Subject: Eagle Rising SP205 Preliminary Plan Reinstatement

Submittal Name:		EDARP Review Comments											
Project Name:		SP205 - Eagle Rising Preliminary Plan Reconsideration											
		September 7, 2023 submittal

STREAM VEGETATION  
PHOTO LOCATIONS

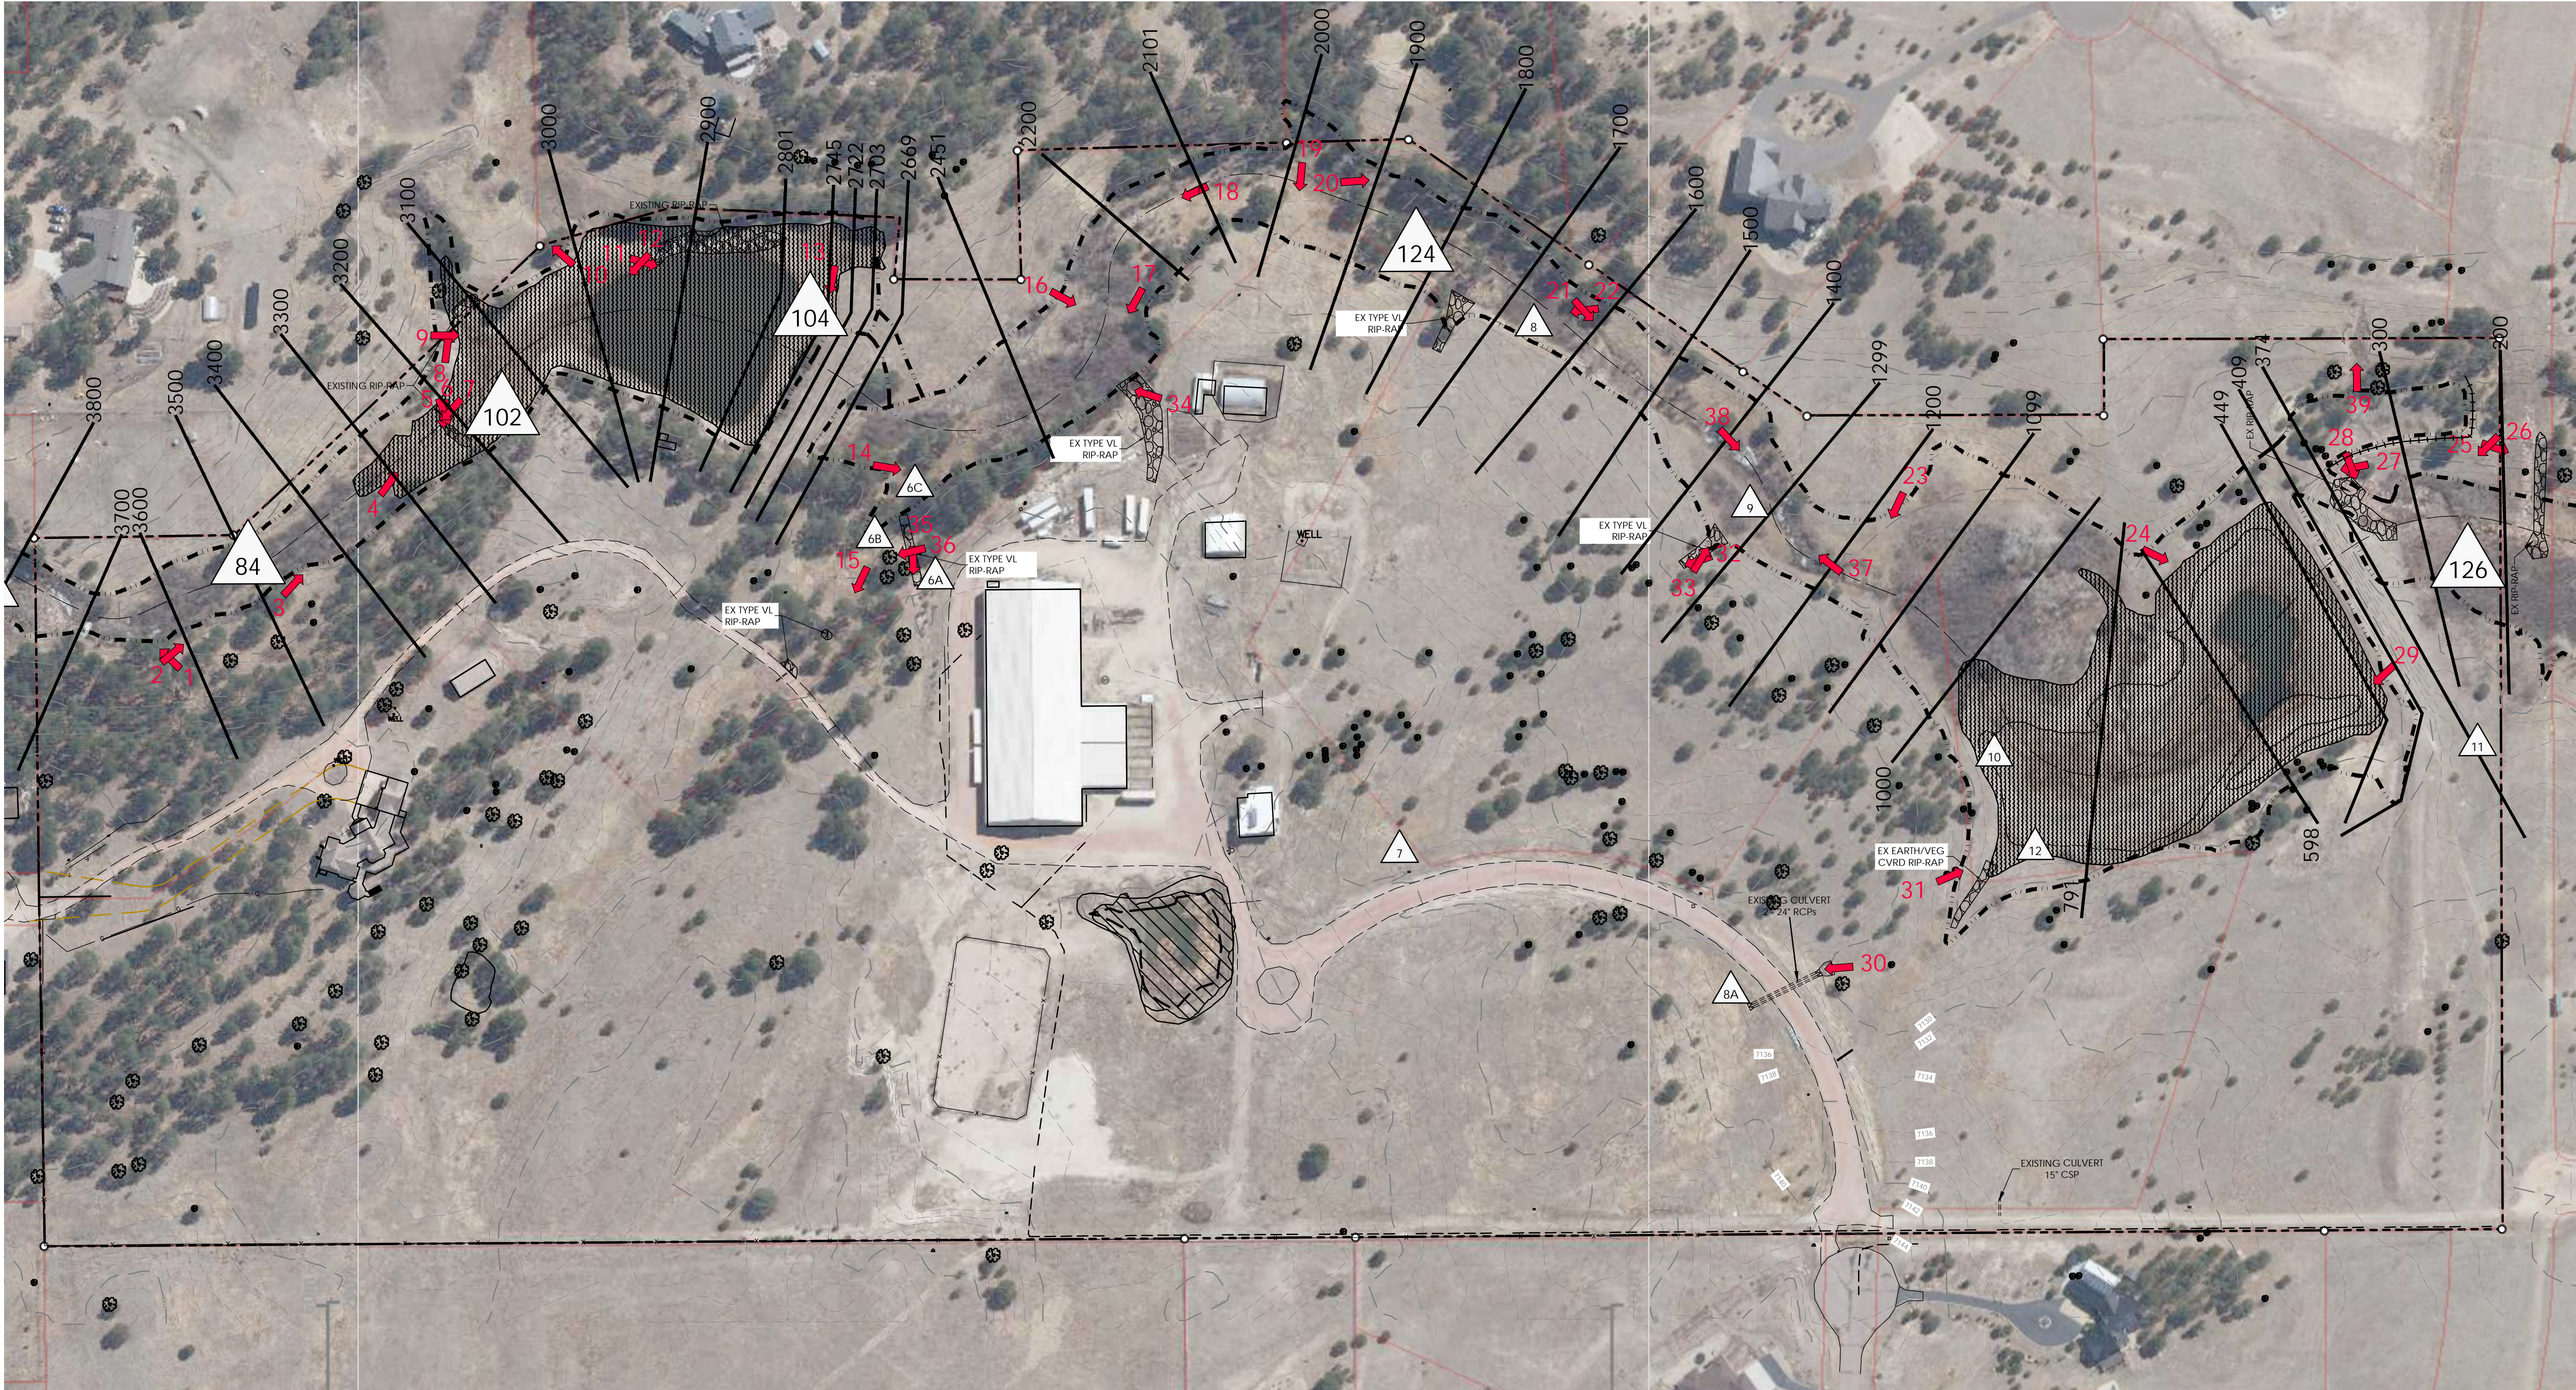
24	Master Development Drainage Plan / Preliminary Drainage Report	PCD Engineering Division	Yes	Jeff Rice	9/29/2023 16:00	(MDDP/PDR redlines)	187	Purple lines are parallel to areas of the channel Staff would like pictures of or site visit to see	C - Disapproved	11/3/2023	Eagle Rising Master Development Drainage Plan / Preliminary Drainage Report Nov 2, 2023	multiple	See Photo #3 and #4 for Design Point 84 See Photo #16 and #17 for Design Point 104 See Photo #18, #19, and #20 for Design Point 124 See Photo #25 and #26 for Design Point 126 See pictures provided in ERO Natural Resources Assessment Eagle Rising Subdivision Meeting Resolution and recorded with Meeting Notes on 10/25/23 with El Paso County Staff was Reolved with: "Preliminary Drainage Report / Plans: Channel stabilization, maintenance access. Site visit by Palmer and LaForce, (excluding Rice), with Development Team members. Noted that the Eagle Rising Development will not add to the stormwater flow in the creek. Gorman to research to provide information to support that the existing well established willow vegetation can withstand 5 fps velocity. Then prepare a deviation request."

EXHIBIT

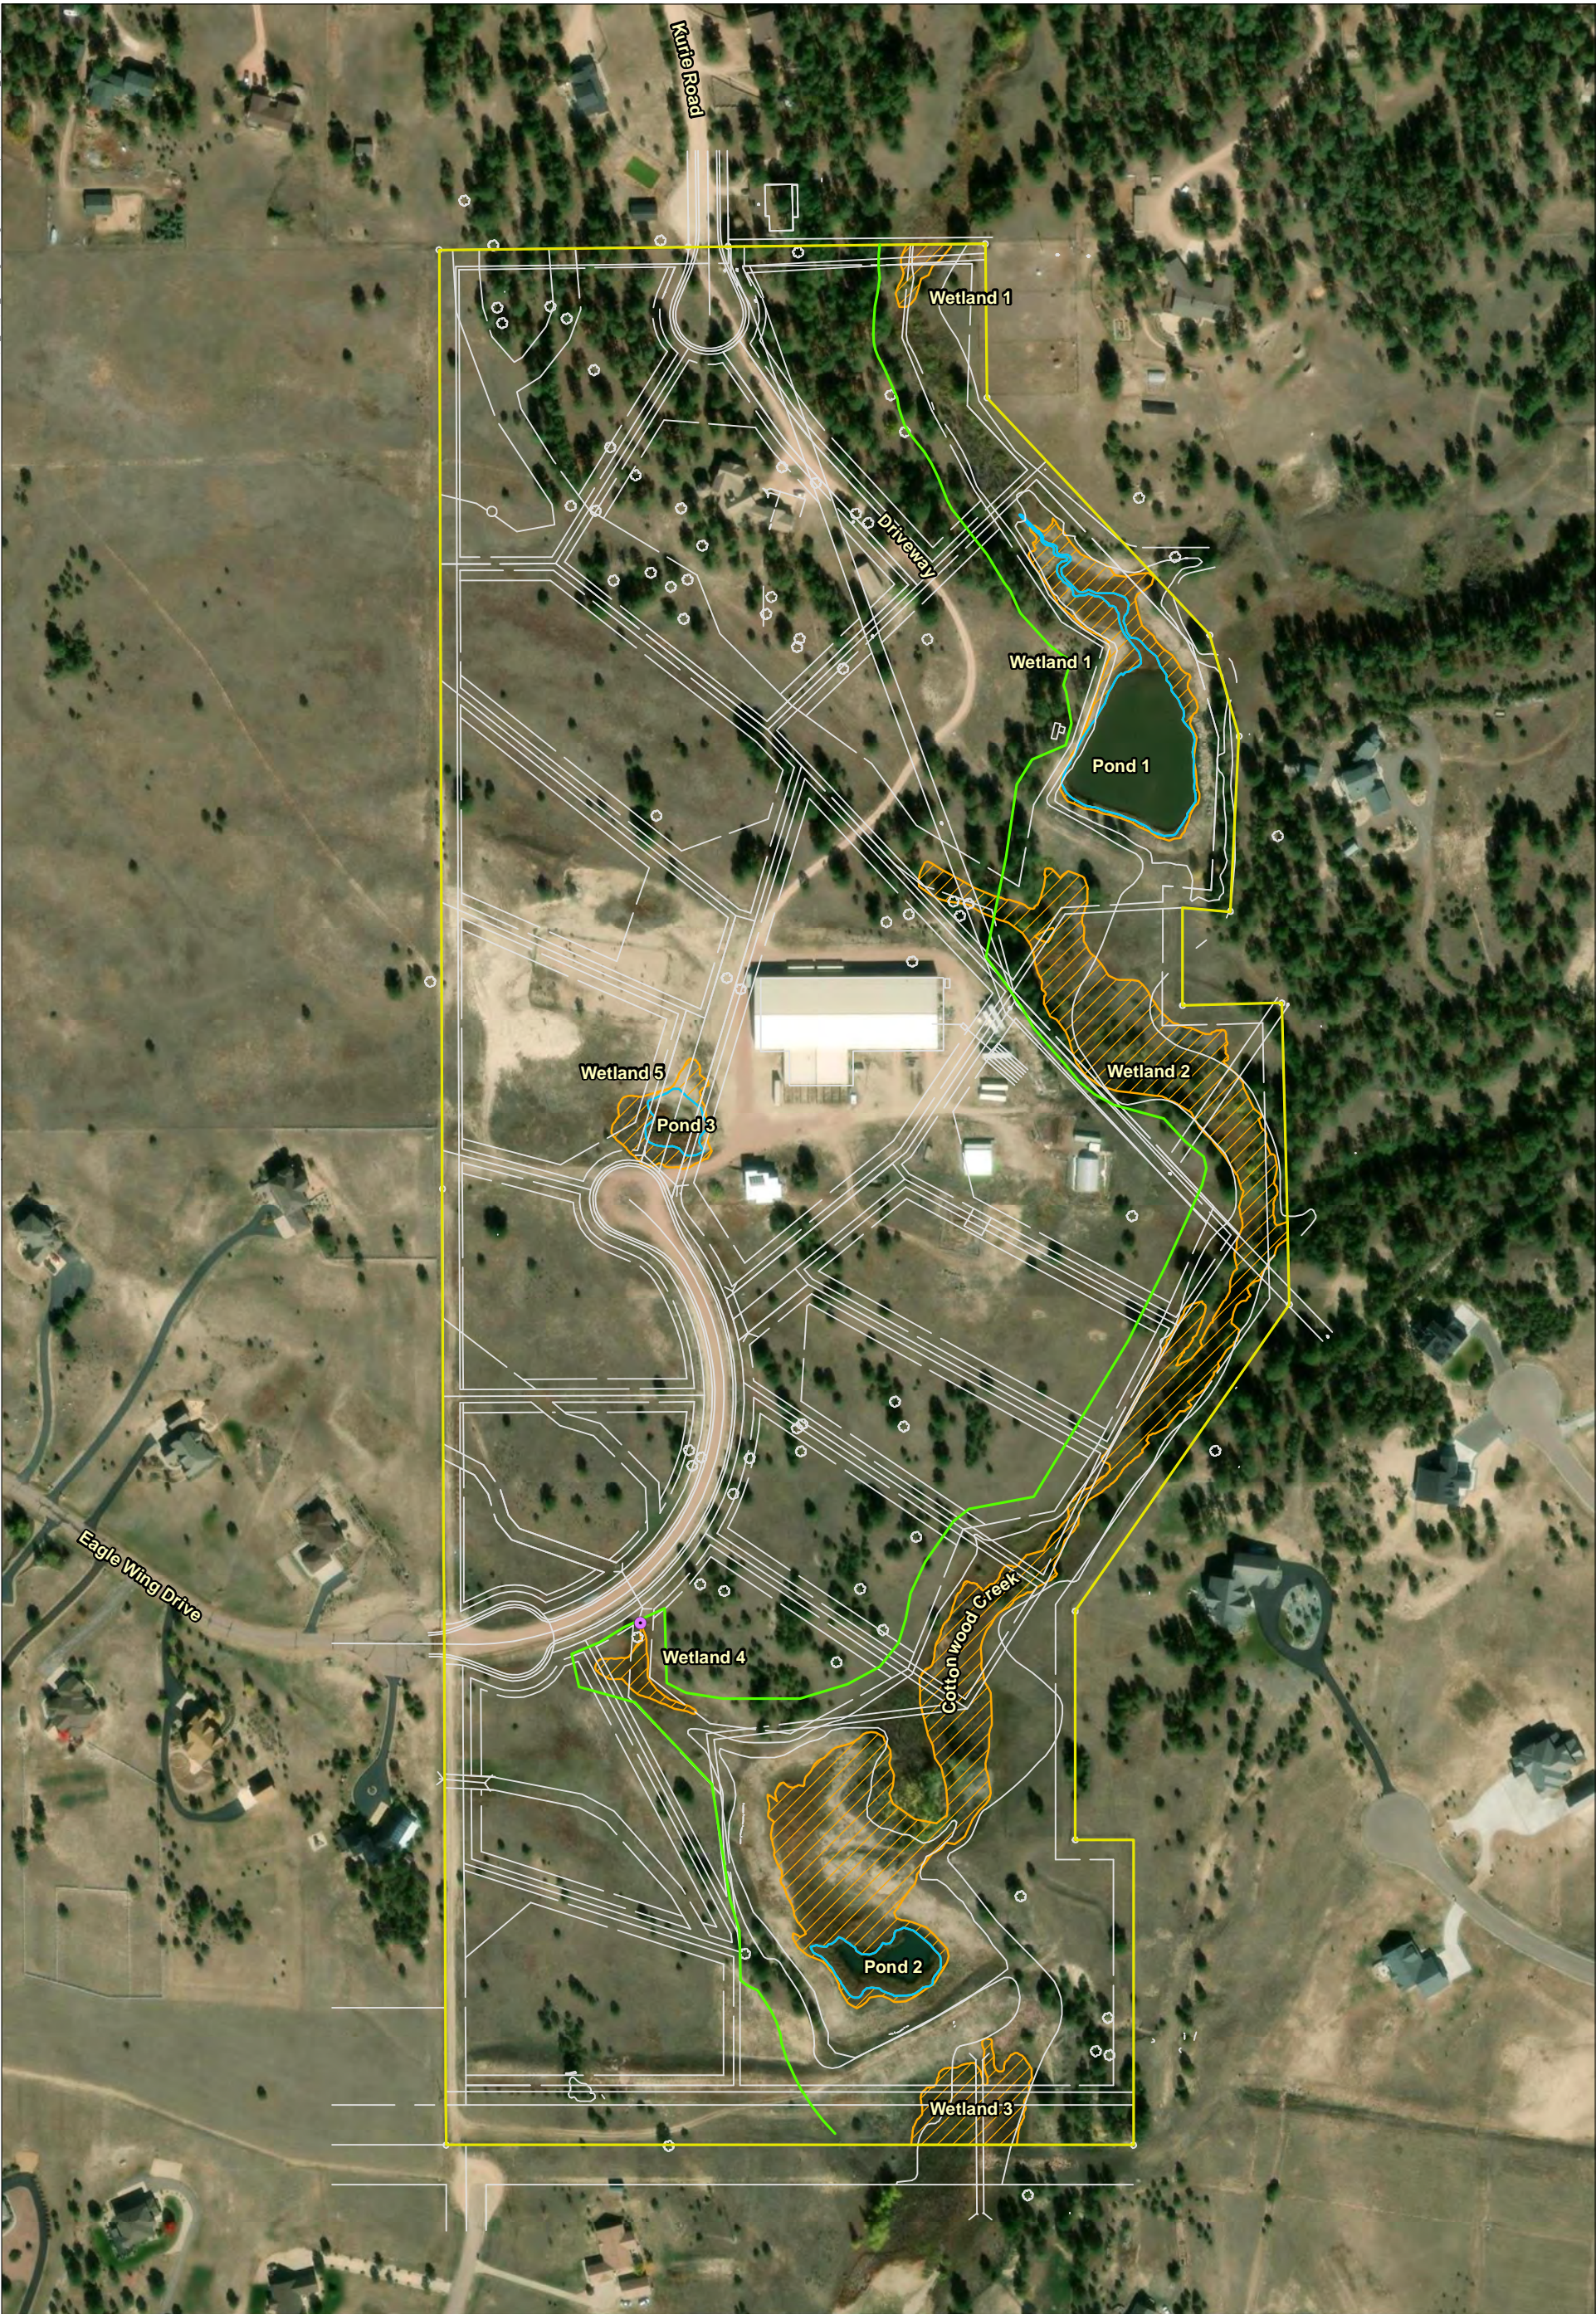
Per-meeting agreement on October 25, 2023, we are supplying additional reports about the ability of native existing well-established vegetation to resist erosion along the creek, in our MVE, Inc. Engineers MDDP/Preliminary Drainage Report and our Deviation Waiver to the Drainage Criteria Manual. The MDDP/Preliminary and Final Drainage Reports already include photographs of existing vegetation specific to Design Points, as do all our ERO Reports from 2012-present. A U.S. Army Corps of Engineers, USACOE representative visited the property April 27, 2023, and recommended that our section of Cottonwood Creek is best left as a natural channel with no disturbance including no construction of access roads.
